Office of
Environment
& Heritage

Your reference: 05_0157
Our reference: DOC13/68887
Contact: Rachel Lonie, 99956837

I refer to your correspondence dated 2 October 2013 to the Office of Environment and Heritage (OEH) inviting comment on the Preferred Project Report for the building and construction of a Waste Recycling Facility at Moorebank (05_0157) in the Liverpool Local Government Area.

OEH comment on the Preferred Project Report for the building and construction of a Waste Recycling Facility at Moorebank (05_0157) in the Liverpool Local Government Area.

Figure 7-1: Vegetation of the Site. 1 refers to Cleared Area, 2 to Wattle Scrub, 3 to Ironbark Open Forest, 4 to Woollybutt - Blue Box Open Forest, 5 to Cabbage Gum Open Forest and 6 to Swamp Oak Woodland.

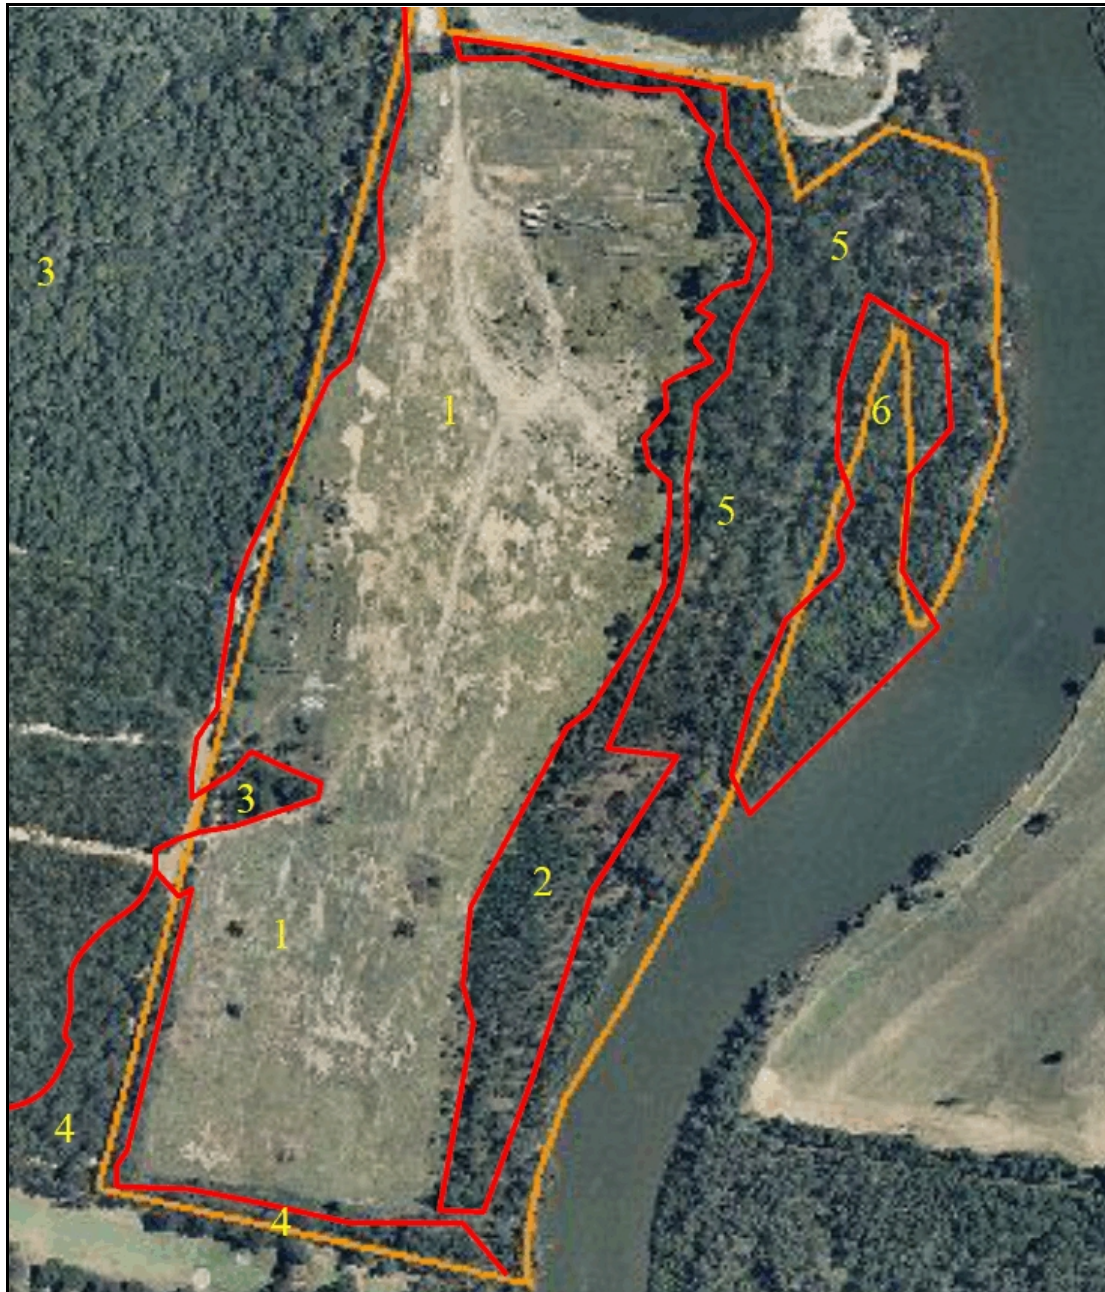
It is also recommended that the EMP be expanded to include a subsection on vegetation management for the entire site to ensure that all native vegetation to be retained is appropriately fenced off and protected both during construction and operation of the facility. This should include the area of Ironbark Open Forest on the south western boundary and along the batter wall to create a barrier along the eastern edge where the cleared area adjoins native vegetation.

It is noted that this vegetation is mapped as River Flat Eucalypt Forest (RFEF), Swamp Oak Forest and Coastal Saltmarsh in the draft Sydney Catchment Management Authority vegetation mapping (see map extract in Figure 1). All three are endangered ecological communities (EEC) under the *Threatened Species Conservation Act 1995*.

The EMP should also include requirements to protect the area of Gravel Transition Forest (also an EEC) as mapped along the south of the site and that is outside the area of earthworks. Note that this mapping identifies the area of Ironbark Open Forest discussed above as RFEF.
